## Department of Transportation

SH 094A/Franceville Coal Mine Road  
El Paso County

LSC Responses To CDOT Comments.

RE: VA256 - Gateway Trucking - Revised Variance of Use and Site Development Plan

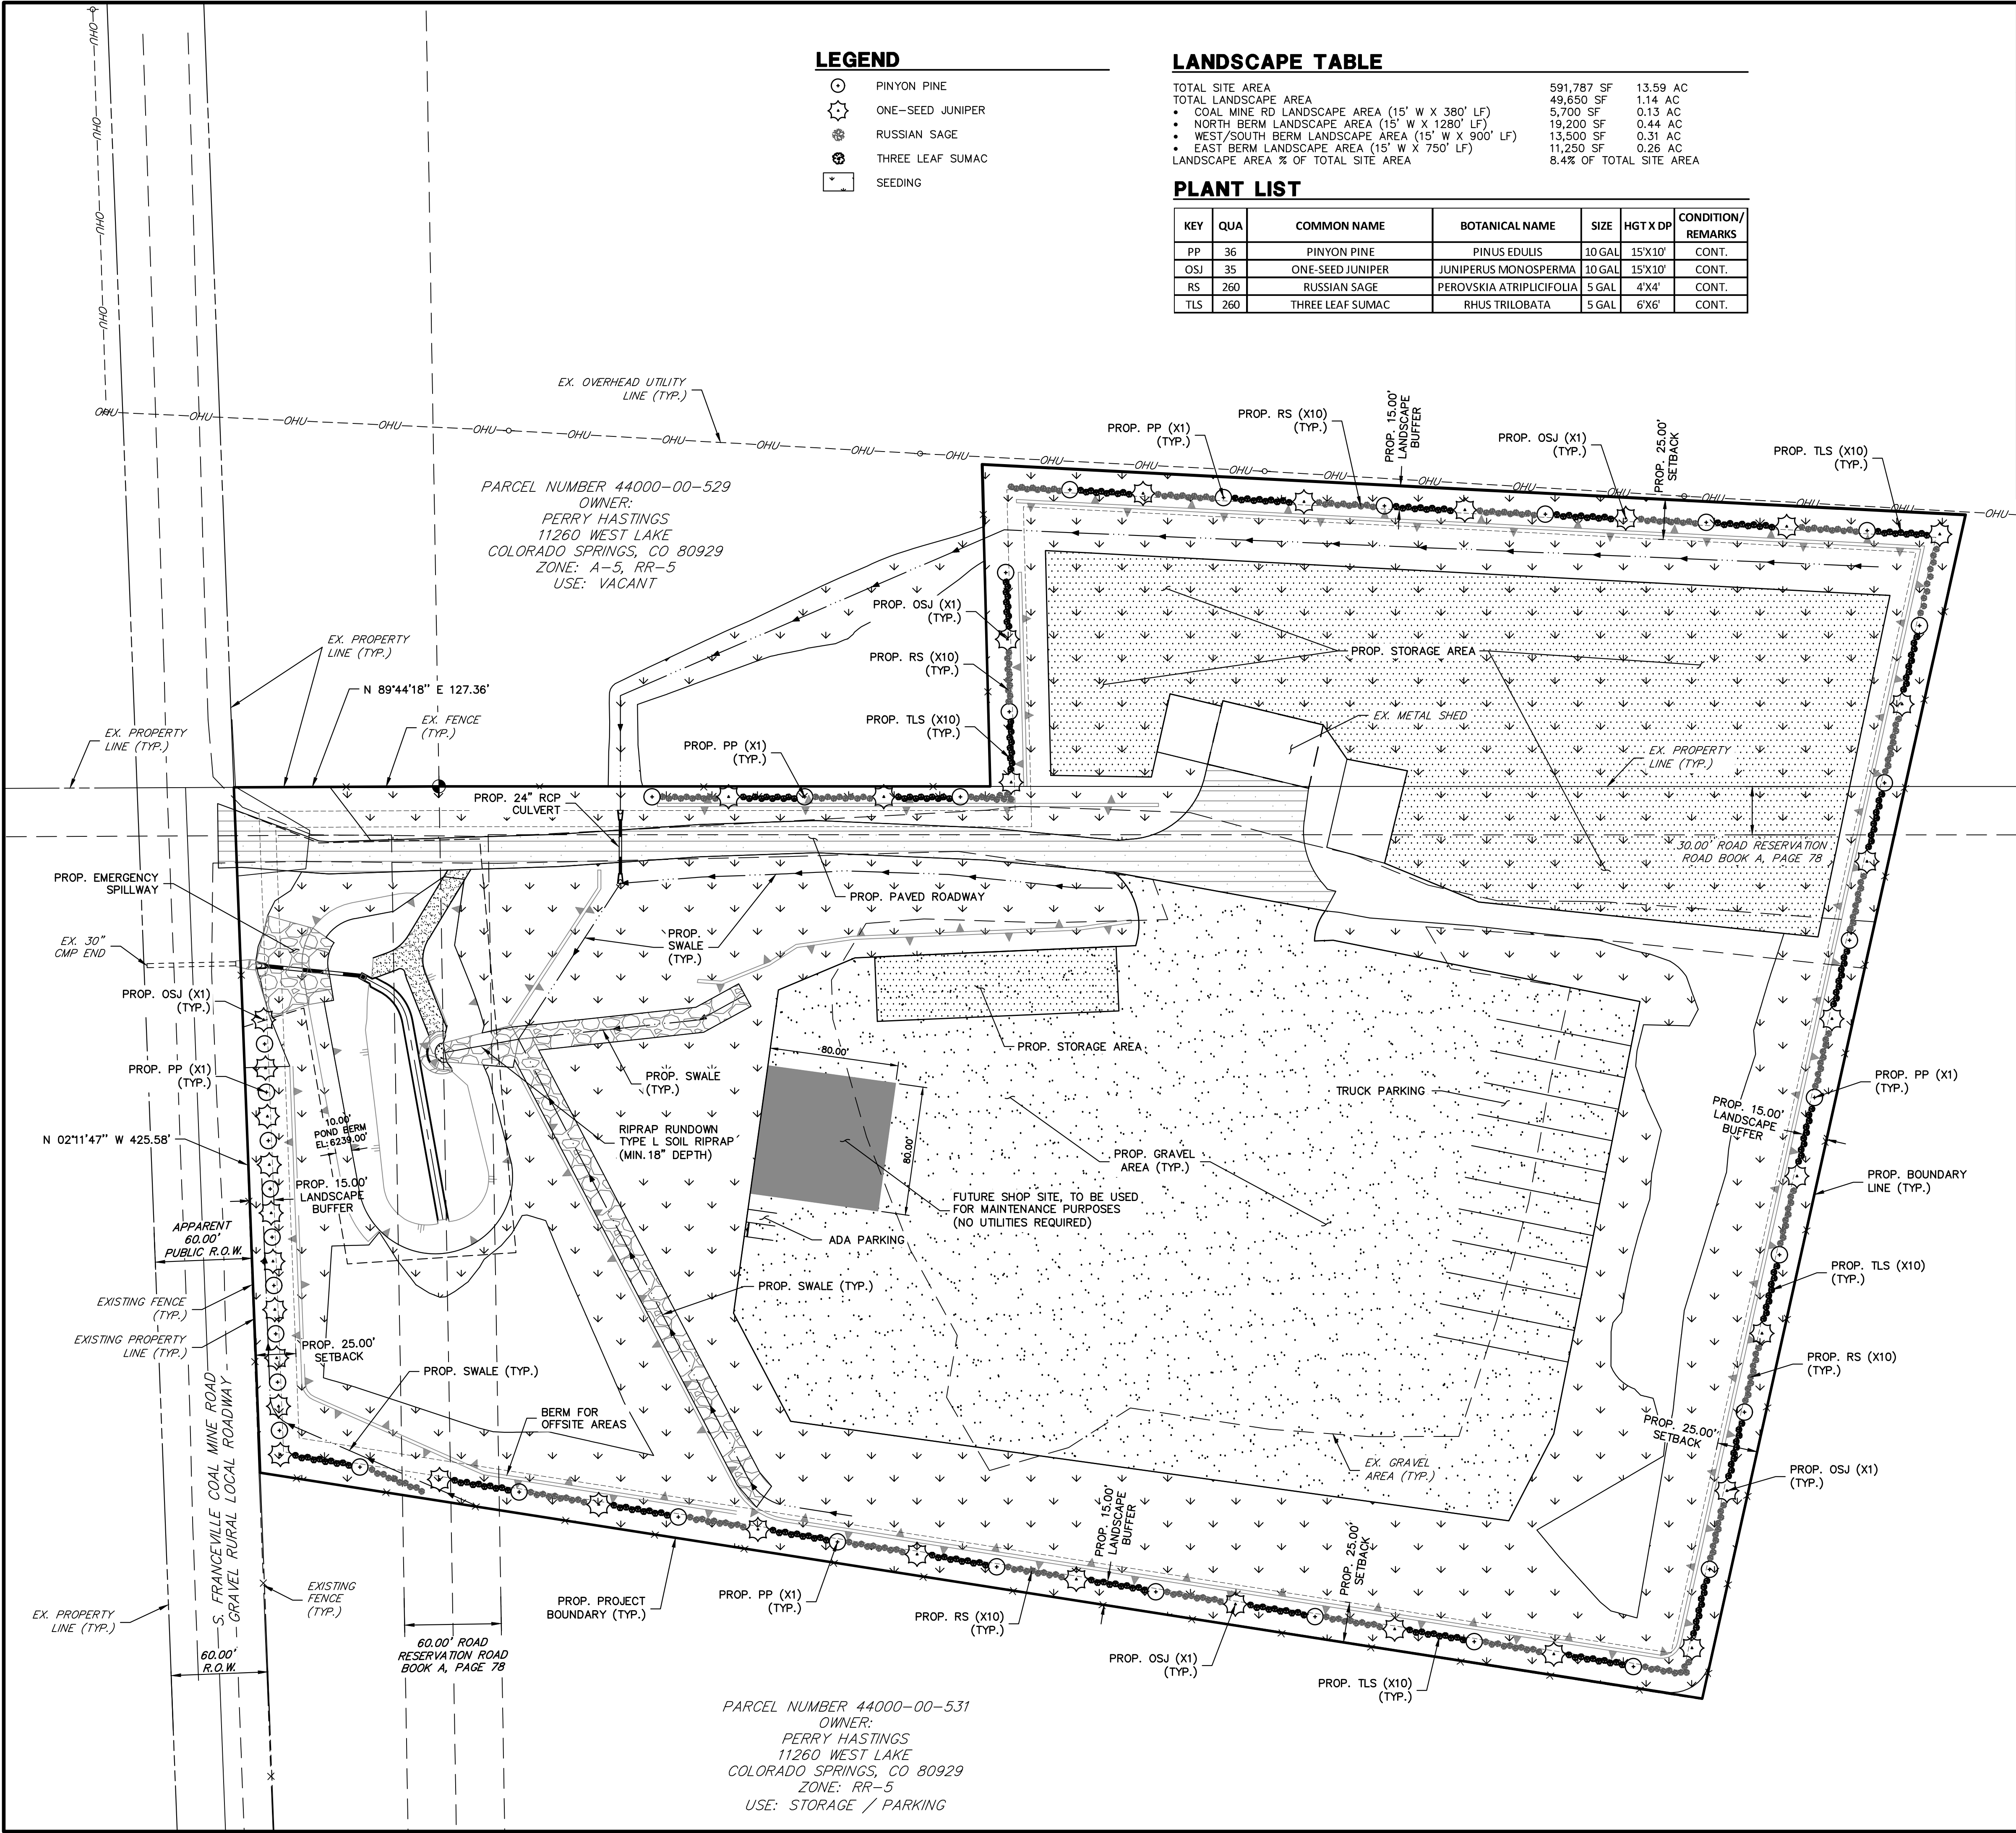
- An eastbound right turn deceleration lane and taper is required on SH94 (500 feet long + 300 feet due overlap of the driveway access to the west + a 300 feet transition taper) with a 4 feet wide paved shoulder and appropriate signage and striping. This may trigger additional application to CDOT Access for the impacts to the access of 12655 SH94.
- A westbound left turn acceleration lane is required as the predicted volume of the traffic in the direction of travel on SH94 exceeds 120 DHV.
- Radiuses of the access are required to be designed and built to allow use by multi-unit trucks without encroachment into other lanes of either roadway.
- Paving of the access (Franceville Coal Mine Road) is required at a width of 36 feet south for a distance of 50 feet at a grade not to exceed 8%.

LSC Response: Please refer to the updated TIS dated May 15, 2026.
